## WEST SUSSEX COUNTY COUNCIL CONSULTATION

| <b>LOCATION:</b>                | Manoss Lea, 9, Manor Park, Bognor Regis, PO21 3JS                                                                                                                                                                                          |
| <b>SUBJECT:</b>                 | P/118/18<br><br>Application for approval of details reserved by condition imposed under P/76/17/PL relating to Condition 3 schedule of materials & finishes and Condition 5 covered & secure cycle parking spaces.                         |

DRG 8A

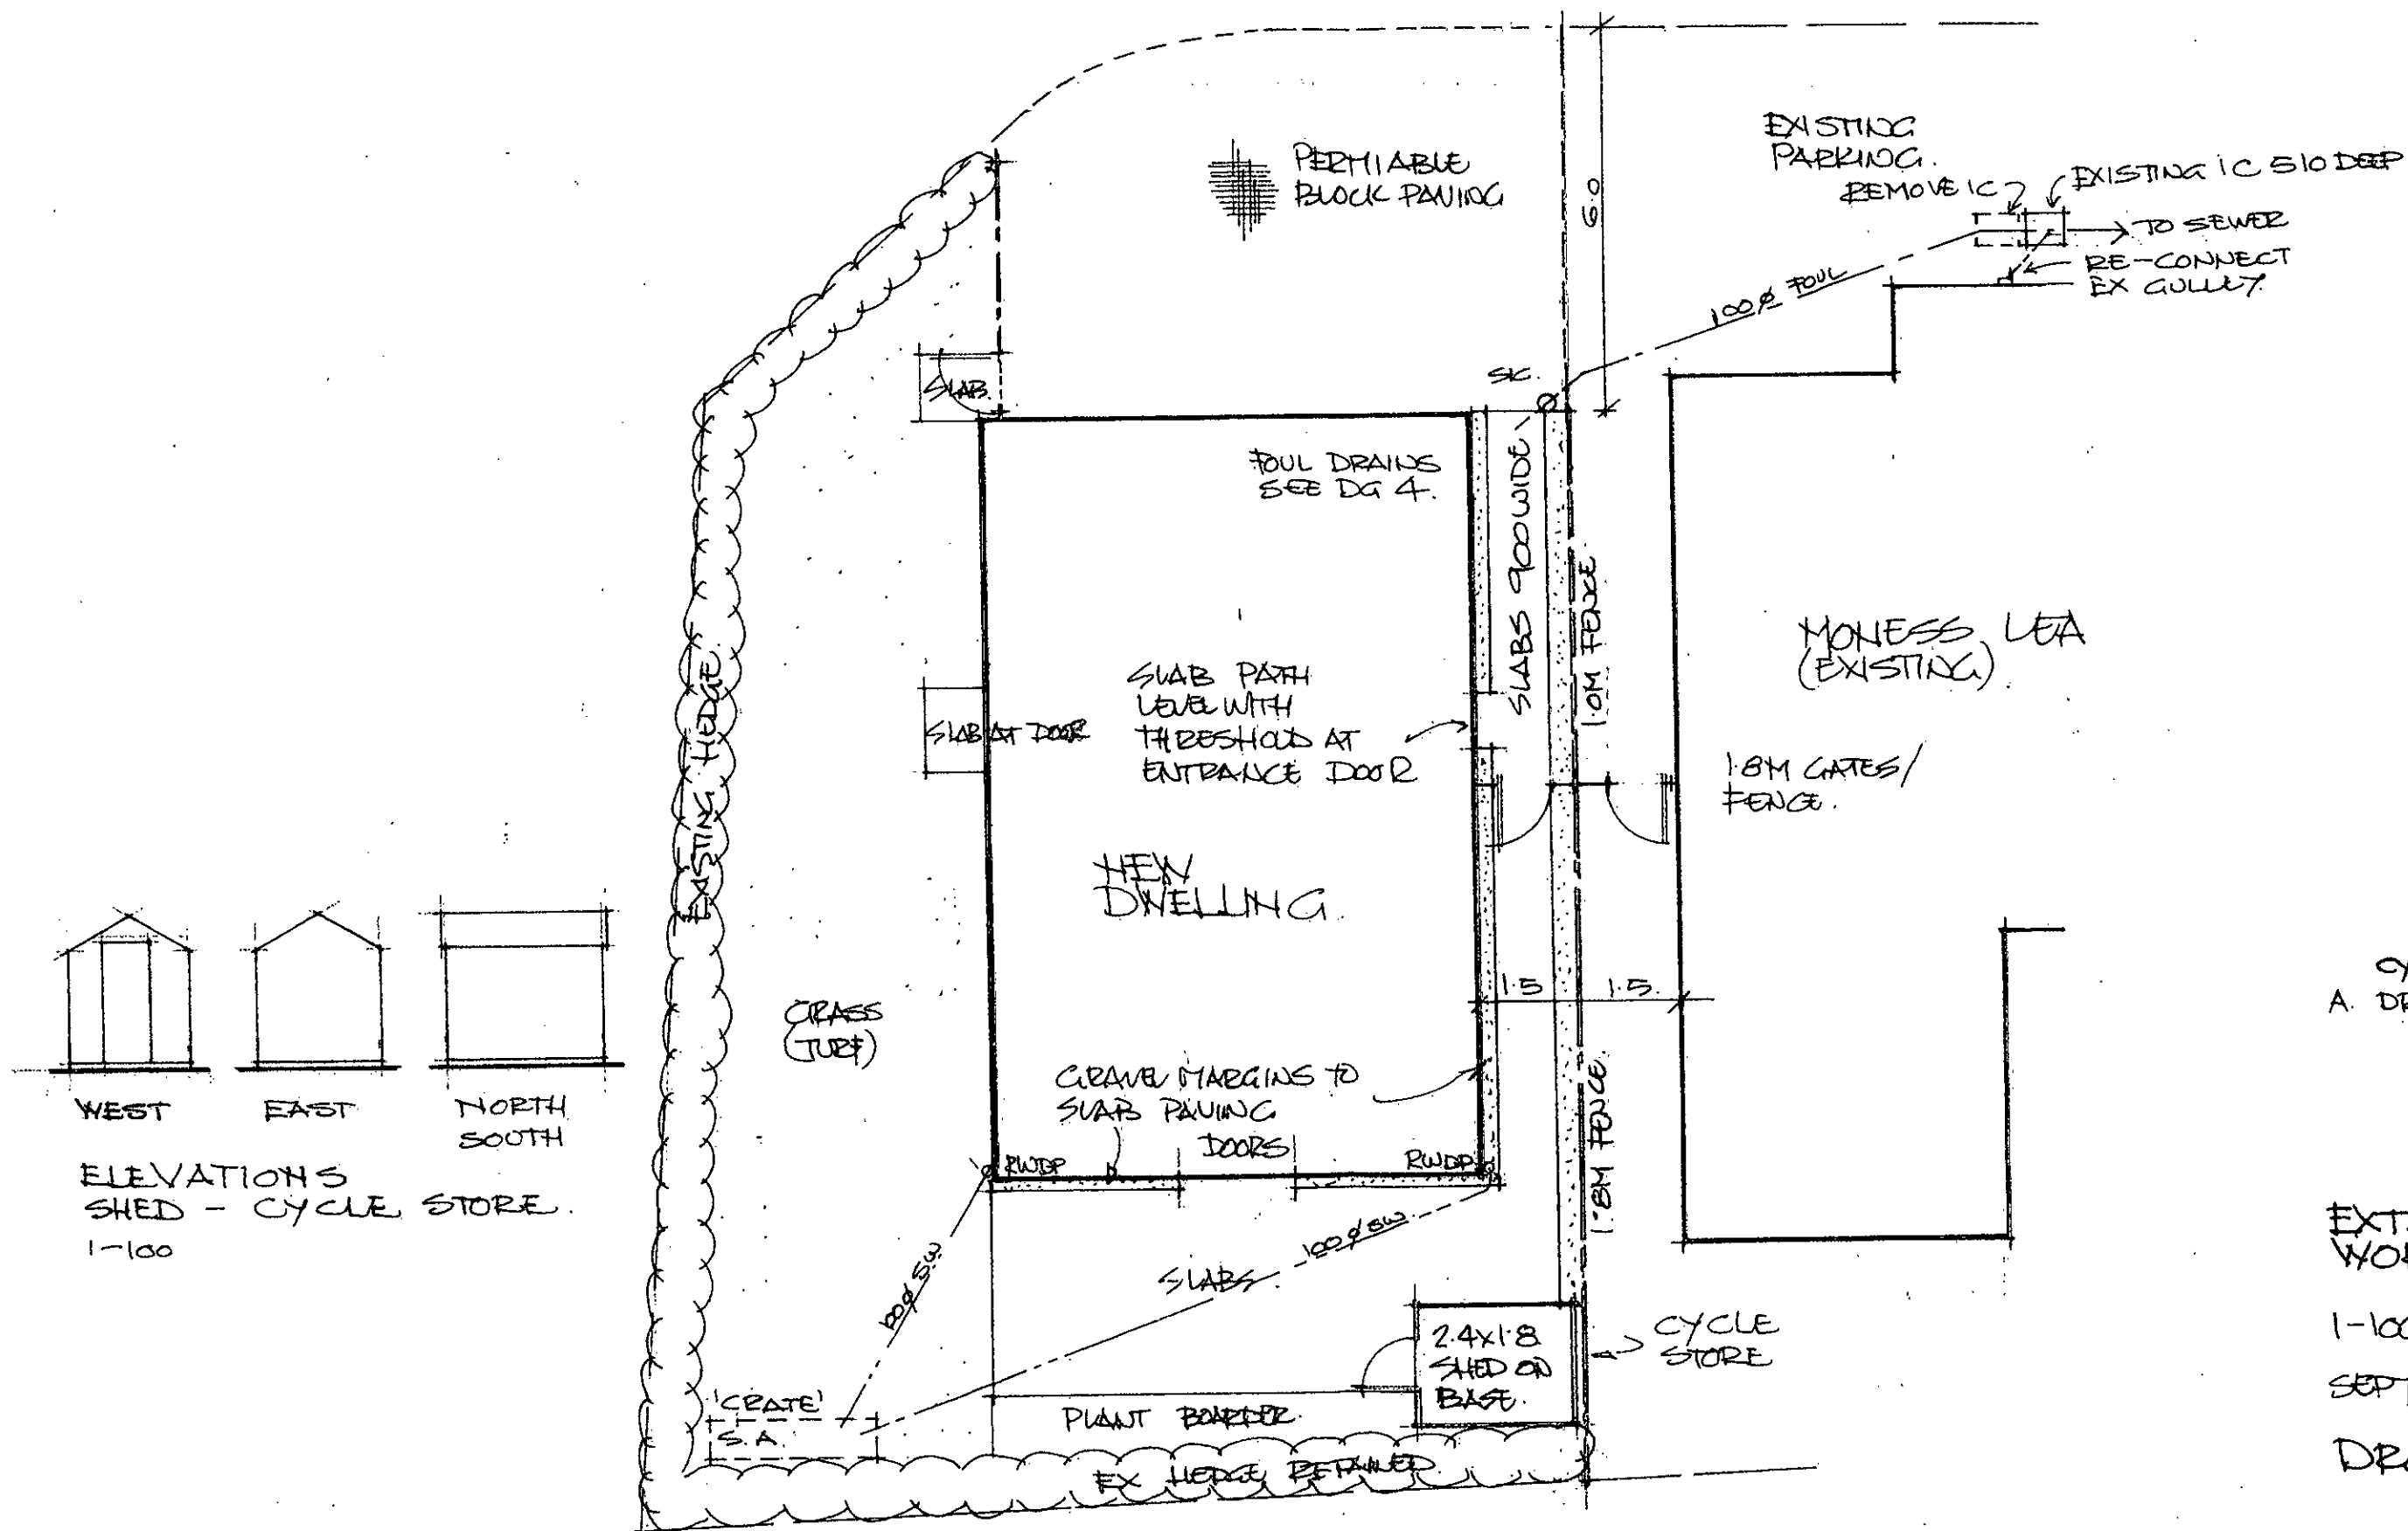
The plans indicate that a shed will be provided in the rear garden to provide secure and covered bicycle storage space. The plans and details pertaining to the condition are acceptable.
